From: Wright, Aaron <[REDACTED]>
Sent: 12 April 2017 16:47
To: Claire Potts
Cc: Lucy Harding
Subject: AL10716RES - revised plans (email 1)

From: Claire Potts <[REDACTED]>
Sent: 12 April 2017 11:10
To: Wright, Aaron <[REDACTED]>
Cc: Lucy Harding <[REDACTED]>
Subject: FW: *Ext: RE: AL10716RES_DRAFT CONDITIONS+AW

From: Sue Howell
Sent: 11 April 2017 17:18
To: Lucy Harding
Cc: Claire Potts
Subject: RE: *Ext: RE: AL10716RES_DRAFT CONDITIONS+AW

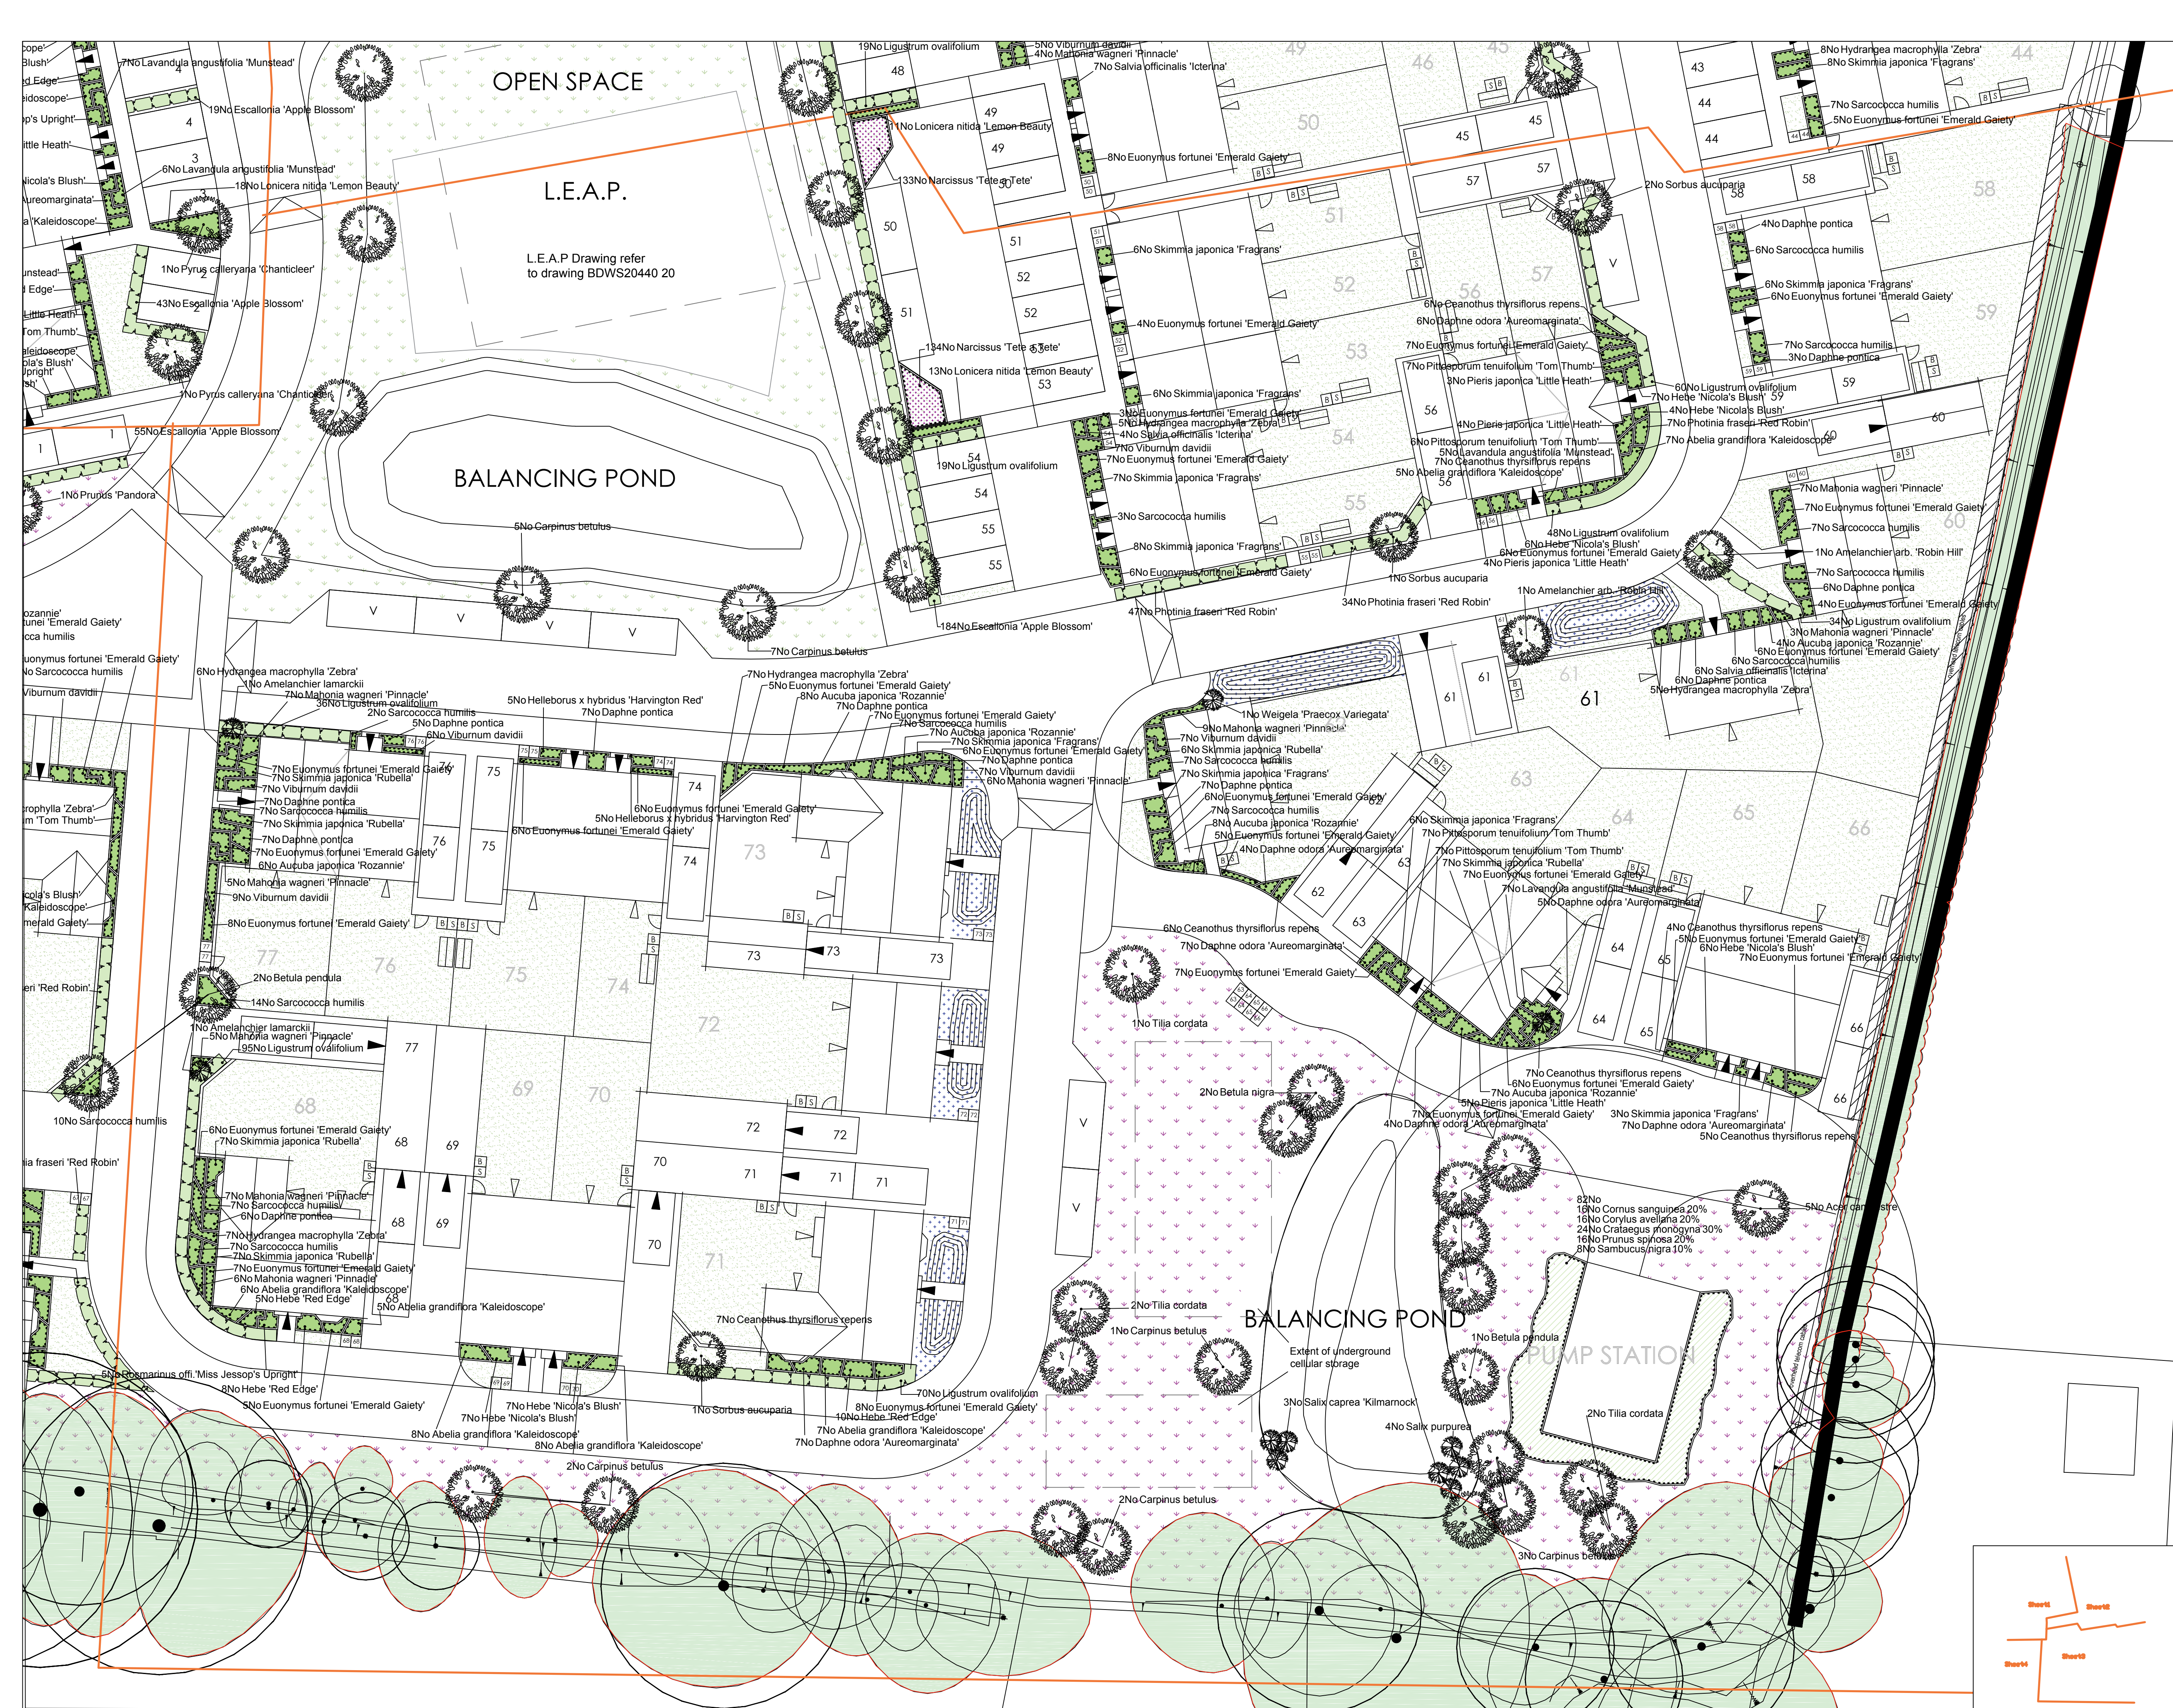
I have had a look at the attached revised plans, which the general landscape arrangement across the drawings is fine. We had however discussed some provision of planting to the periphery of the central balancing pond adjacent to the LEAP, which does not appear to feature on these plans?

There is now a very token of planting to the balancing pond adjacent to the pumping station (7no Salix) but nothing detailed to the central one? Which is where we would have liked to have seen the addition of some groupings of water tolerant planting. Not sure if this is an intended omission or if the developers were given this feedback or not?

In summary the general Landscaping scheme is fine, so too is the addition to provide a 1.2m post and rail fence to the pond edges, we would however recommend the addition of further planting be proposed to both of the balancing pond edges.

Please find attached the revised landscape drawings. The plans show SUDS Wildflower Turf (WFT-SUD-37) as supplied by Wildflower Turf of similar and approved, within the balancing ponds. The ponds are shown to be enclosed by a 1.2m post and rail fence.
